# Sheringham Shoal and Dudgeon Offshore Wind Farm Extension Projects

Draft Statement of Common Ground with Maritime  
and Coastguard Agency

**Revision B**

Document Reference: 12.12

-  90th percentile with 1nm clearance from DEP North
-  90th Percentile (Tees- Zeebrugge)
-  DEP & SEP Extensions

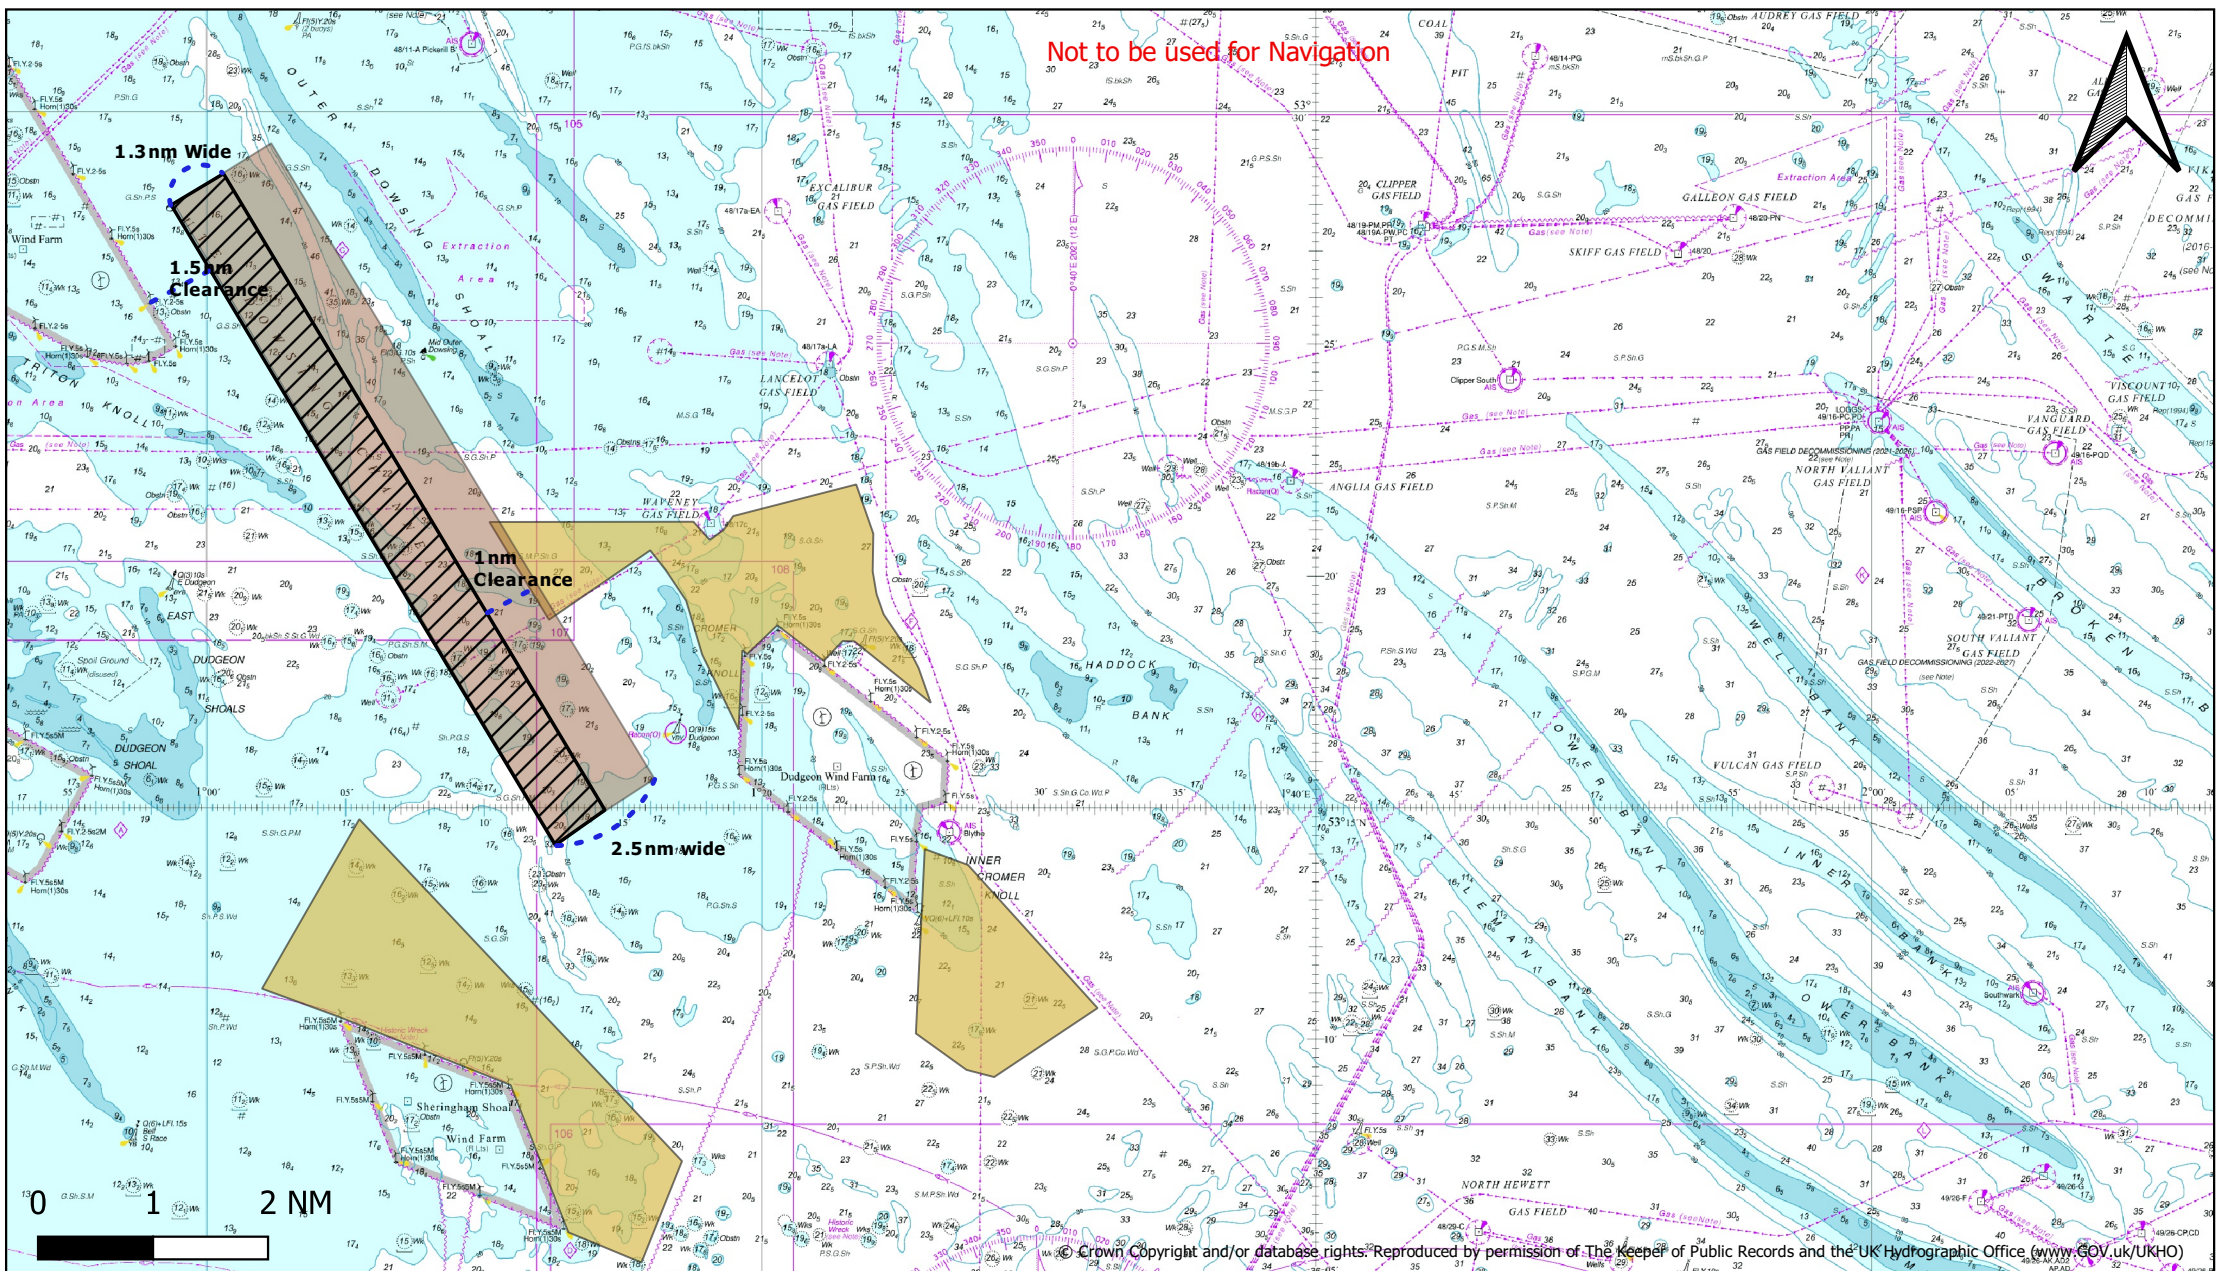
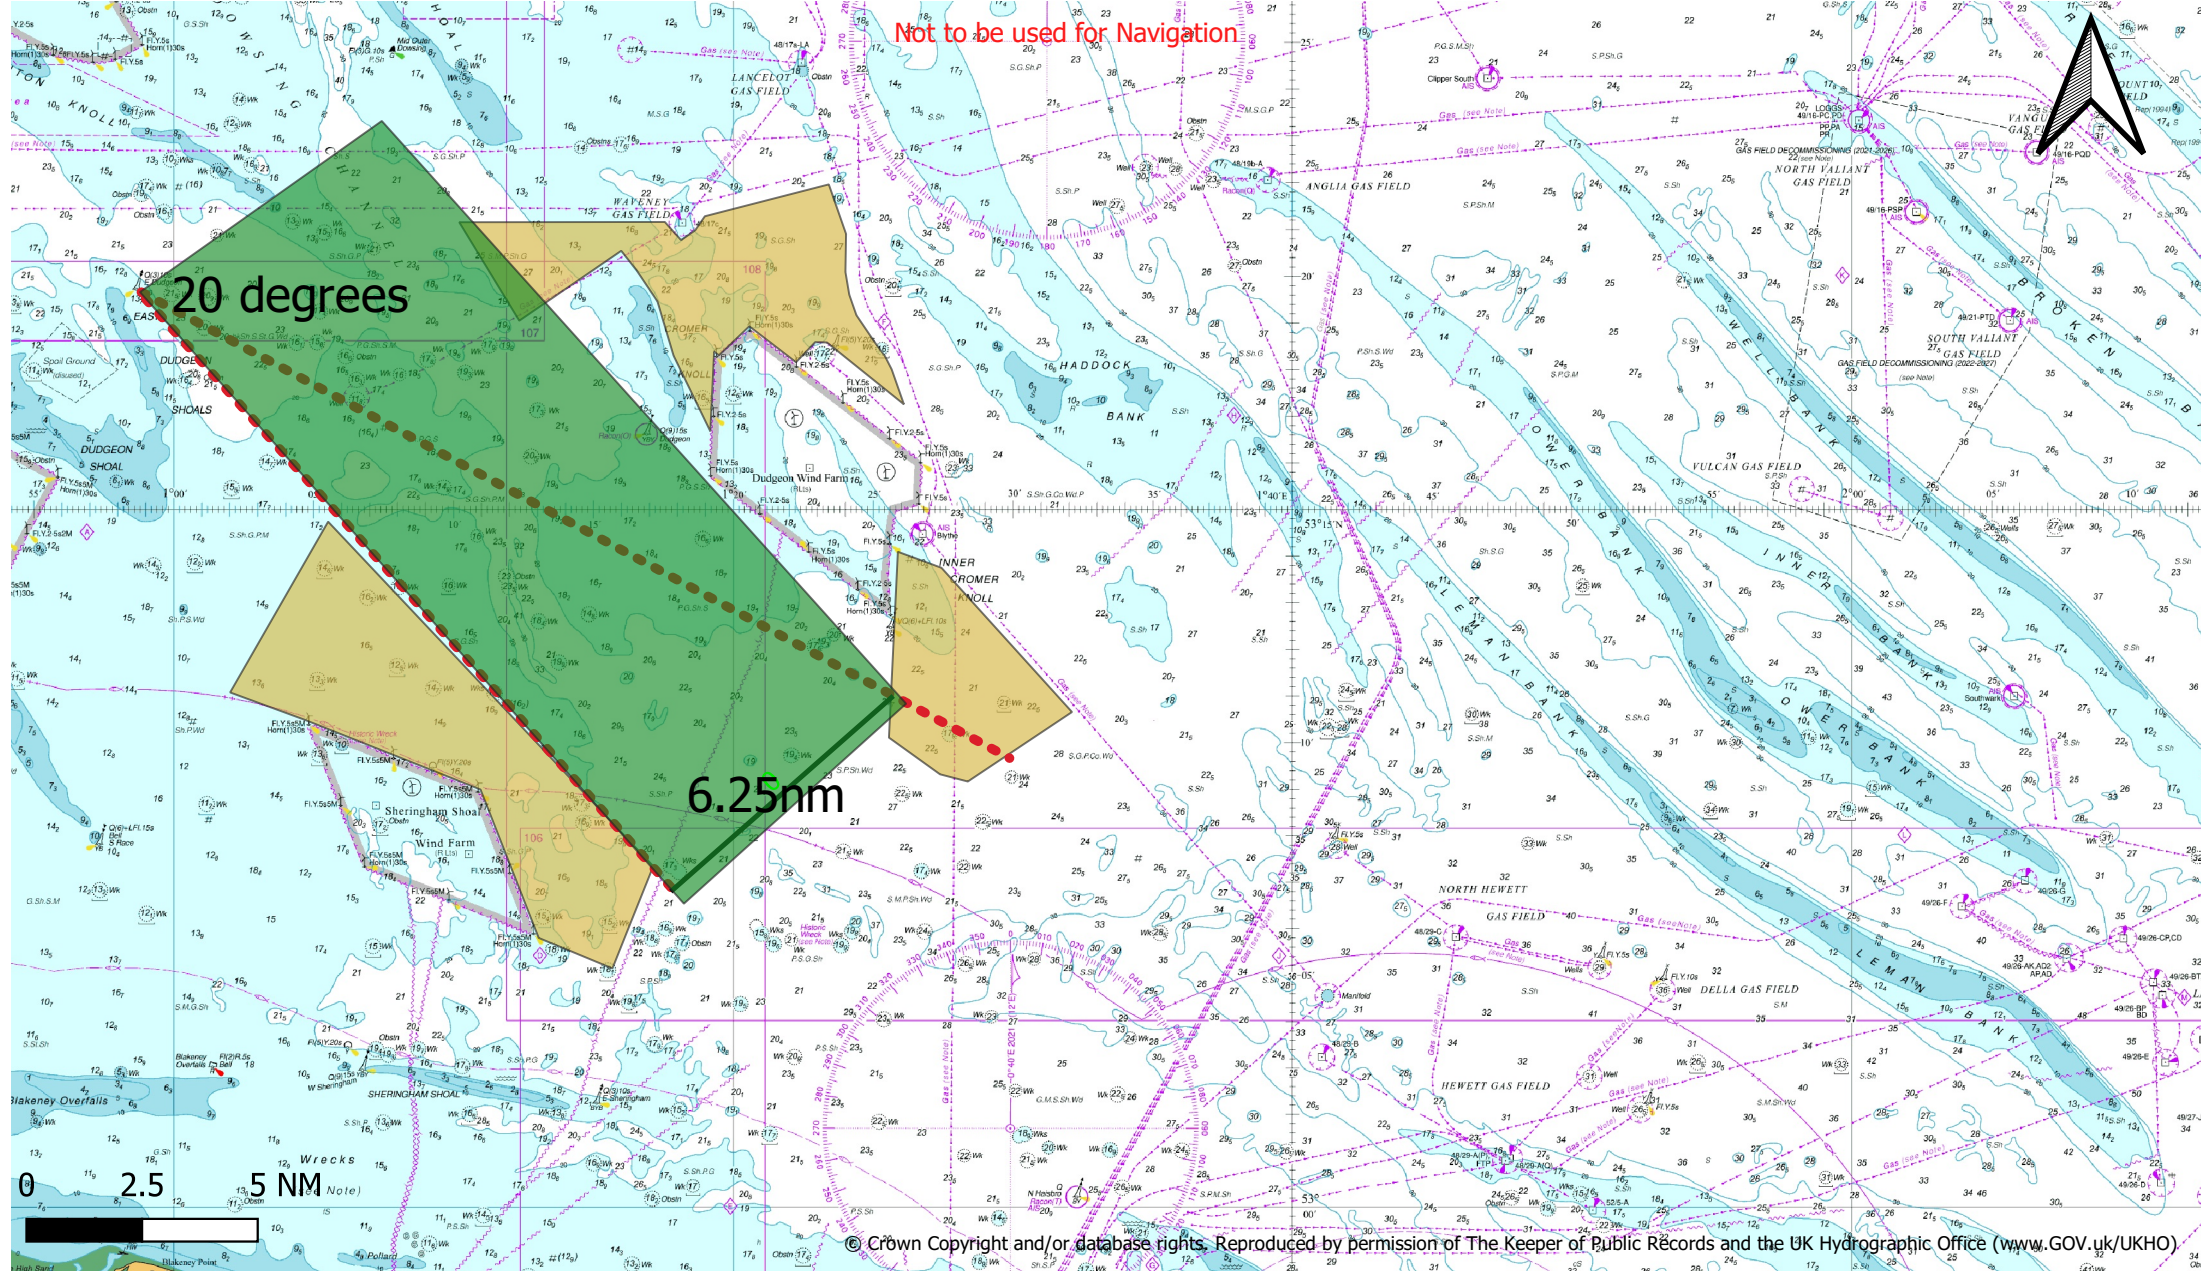
ID	The Applicant Position	MCA Position	Position Summary
	includes the maximum build out of turbines within the site boundaries and consideration of a single line of orientation.		
8	<b>Layout Commitments</b> As per the meeting held on the 11 <sup>th</sup> March 2022 and email dated 29 <sup>th</sup> March 2022 are content with the Layout Commitments detailed in Table 20.2 of the NRA (APP-198).	Agreed	Agreed
<b>EIA – (Impact) Assessment Conclusions</b>			
9	<b>Hazard (Impact) Identification</b> The hazards (impacts) identified adequately capture the potential effects on shipping and navigation that may result from the Project <u>excluding those highlighted in 9(a).</u>	With the exception of 9(a) below, this is agreed.	Agreed
9(a)	<b>Hazard (Impact) Identification - Displacement, Collision Risk and Associated Allision Risk with DEP North</b> The Applicant and MCA have agreed a series of meetings to discuss a resolution.	The MCA retain concerns about available sea room and subsequent collision and allision risk in relation to extent of the RLB to the western edge of DEP North. The hazard log appears to omit third party to third party collision.	Not Agreed – material impact

10	<b>Risk Level (Impact Significance) - Project in isolation</b> Based on the information provided within NRA (APP-198) and the ES Shipping and Navigation Chapter (APP-125) it is agreed that in isolation hazards (impacts), including main route deviations caused by the project and impacts on search & rescue, are unlikely to be significant with the mitigation measure and monitoring detailed in place <u>excluding those highlights in 10(a).</u>	With the exception of 10(a) below, this is agreed.	Agreed
10(a)	<b>Risk Level (Impact Significance) - Project in isolation - Displacement, Collision Risk and Associated Allision Risk with DEP North</b> The Applicant and MCA have agreed a series of meetings to discuss a resolution.	The MCA retain concerns about available sea room and subsequent collision and allision risk in relation to extent of the RLB to the western edge of DEP North.	Not Agreed – material impact
